Case Officer: Gemma Magnuson **Recommendation:** Refuse

Applicant: Mr & Mrs A Pasteur

Proposal: Creation of jib door and stair, and associated works to include the removal of ceiling joists

2018-1014-PL10

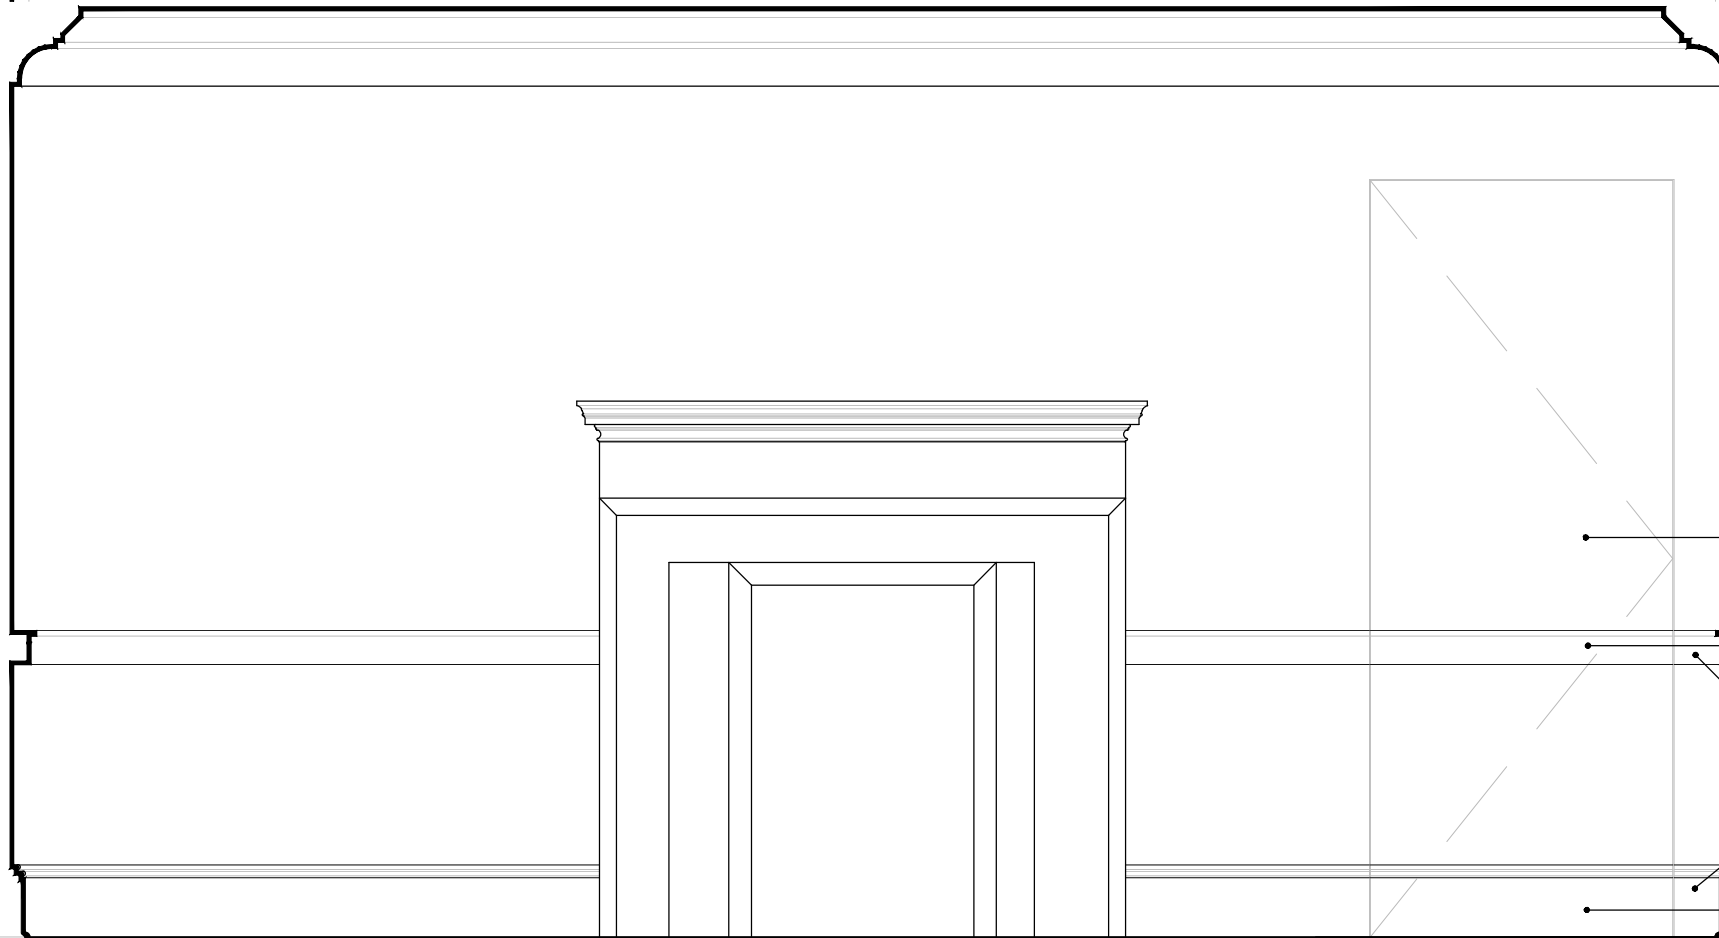
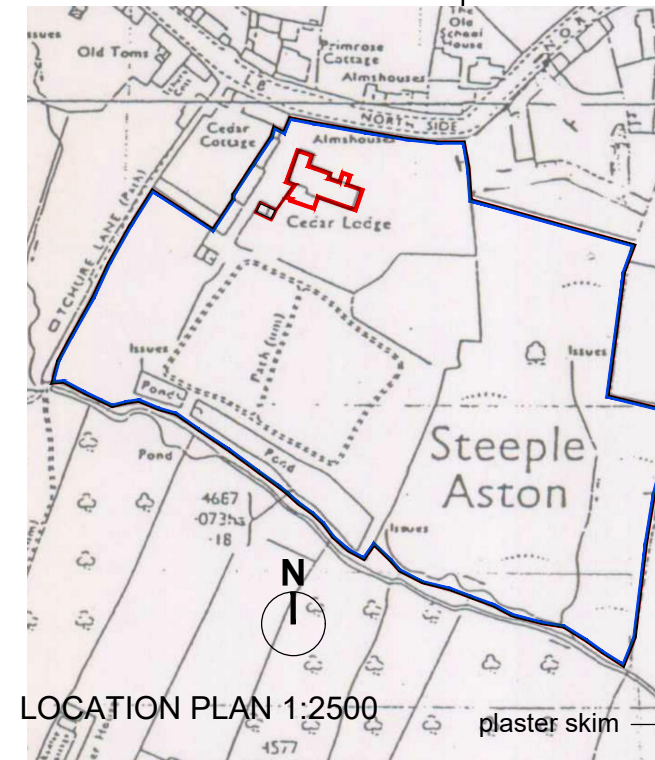
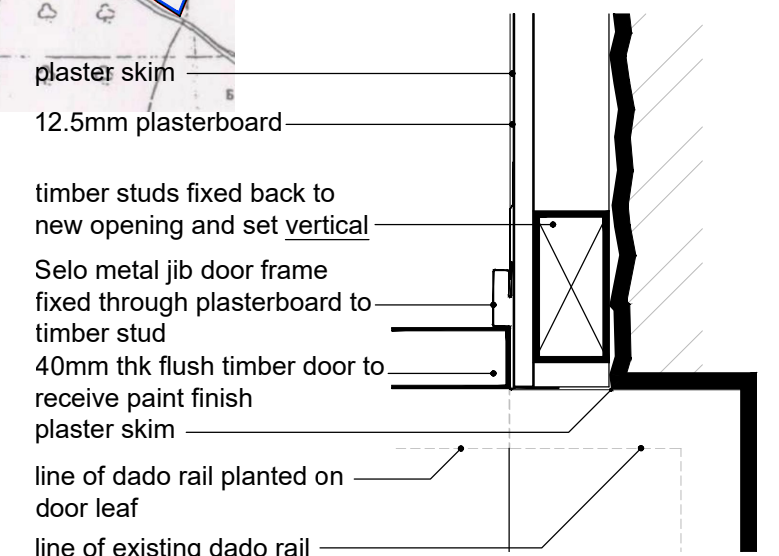
- The fundamental issue is that the proposed development breaches through two physically and functionally distinct areas of the building which causes harm to an understanding of the evolution of the plan form of the building. Regardless of the precise historic evolution of the building the internal character of the 'service wing' is different to that of the principal property which is reflected in the change of levels, lower ceiling heights, relative size of rooms etc.

- In previous applications it was thought that the only historic fabric to be lost was the walling in the gable end, however the return visit to the site revealed that it would also involve the loss of part of the lath and plaster ceiling (which had already been taken down without consent) and ceiling joists in the service wing in order to allow for headroom above the stairs between the two phases of the building.

- 8.10. As the Conservation Officer has advised, regardless of the specific phasing and development of the building, fundamental issues with the proposed breach between these physically and functionally distinct areas of the building remain. The development is considered to lead to harm in terms of the understanding of the evolution of the plan form of the building, with both elements displaying differing characters internally such as the level change, lower ceiling heights and room sizes.

1. The proposed breach through the building would result in less than substantial harm to the significance of the grade II listed Cedar Lodge through the erosion of the distinction between the differing functional areas of the building. In the absence of identified public benefit to outweigh the less than substantial harm identified, the proposal is contrary to Policy ESD15 of the Cherwell Local Plan 2011-2031 Part 1, saved Policy C18 of the Cherwell Local Plan 1996 and Government guidance contained within the National Planning Policy Framework.

SECTION LOOKING WEST 1:50

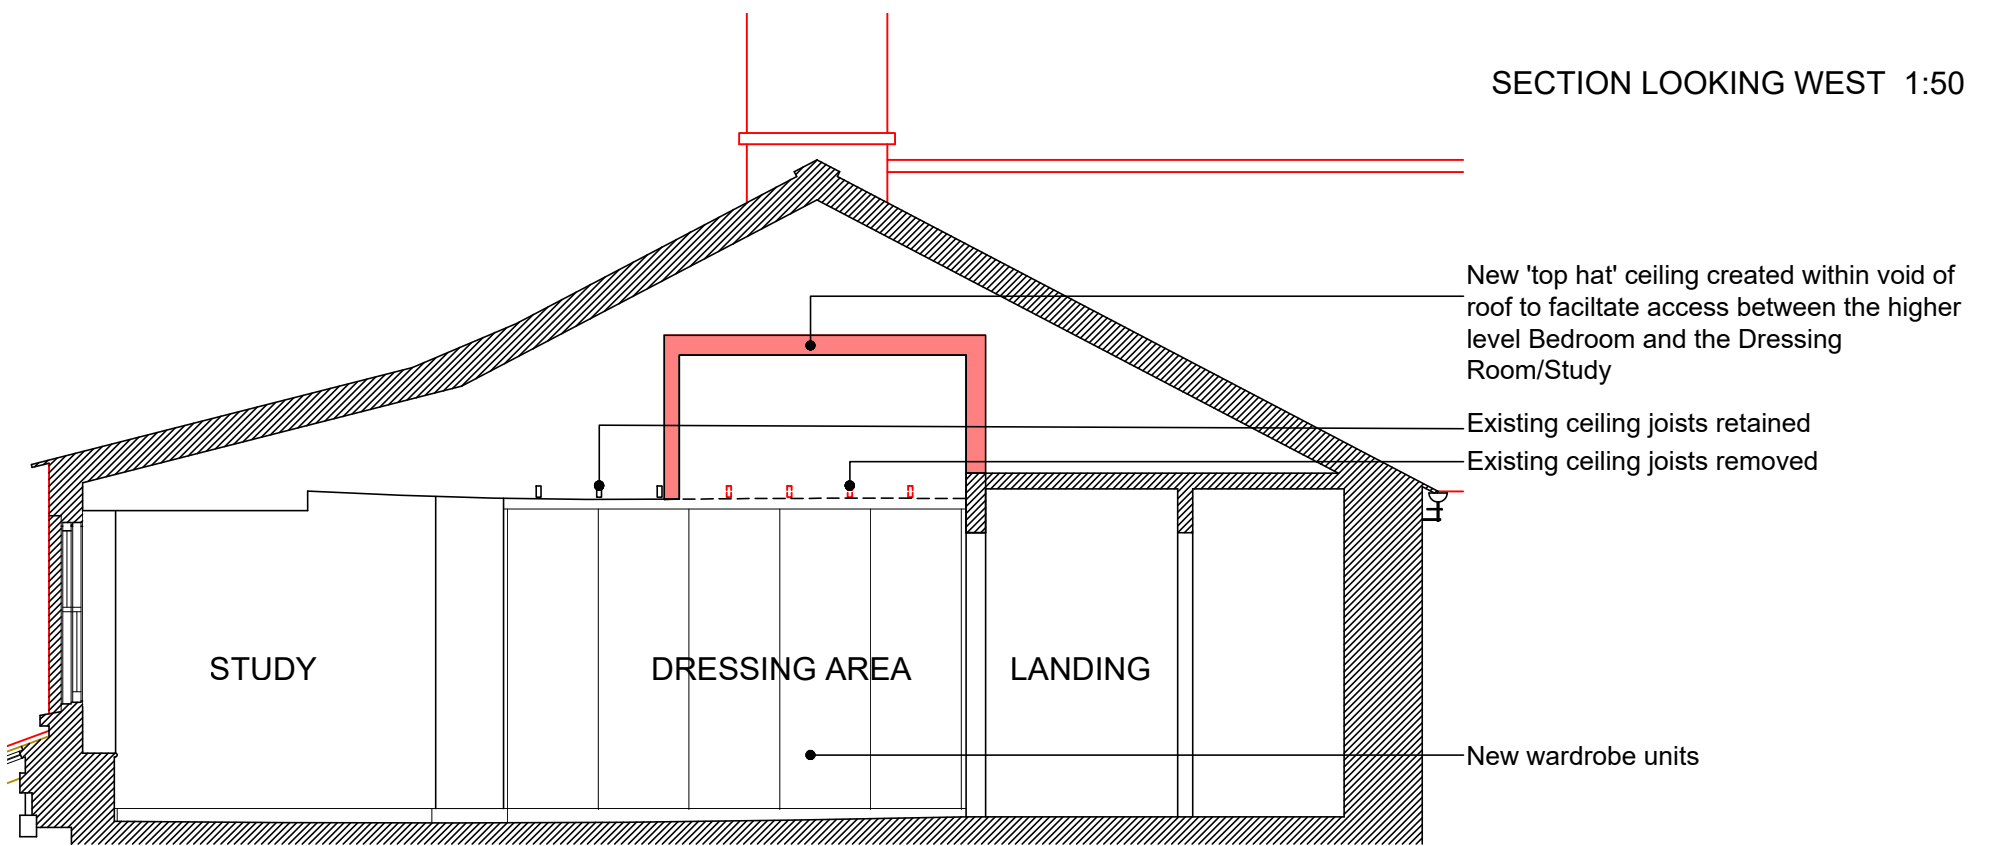
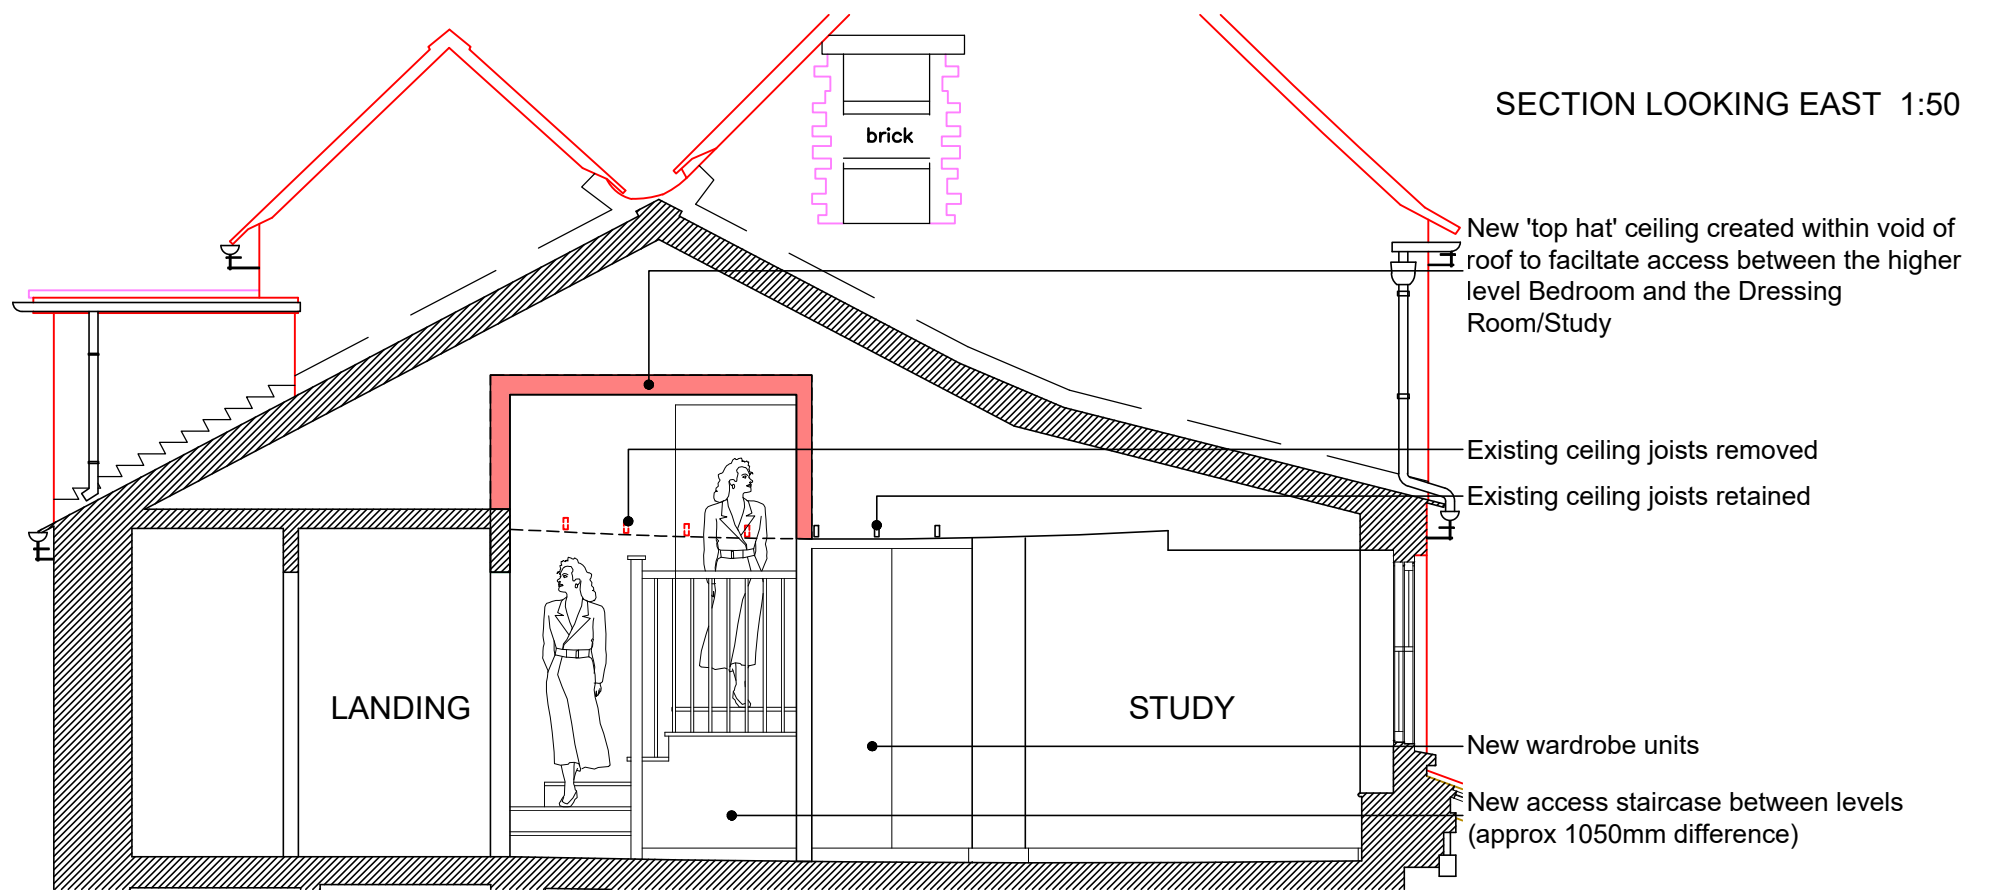
- 8.9. The current application also details the loss of a section of ceiling joists, and lathe and plaster ceiling, an element of the proposal that was not included in previous submissions. The development would therefore involve the loss of more historic fabric than had previously been appreciated.
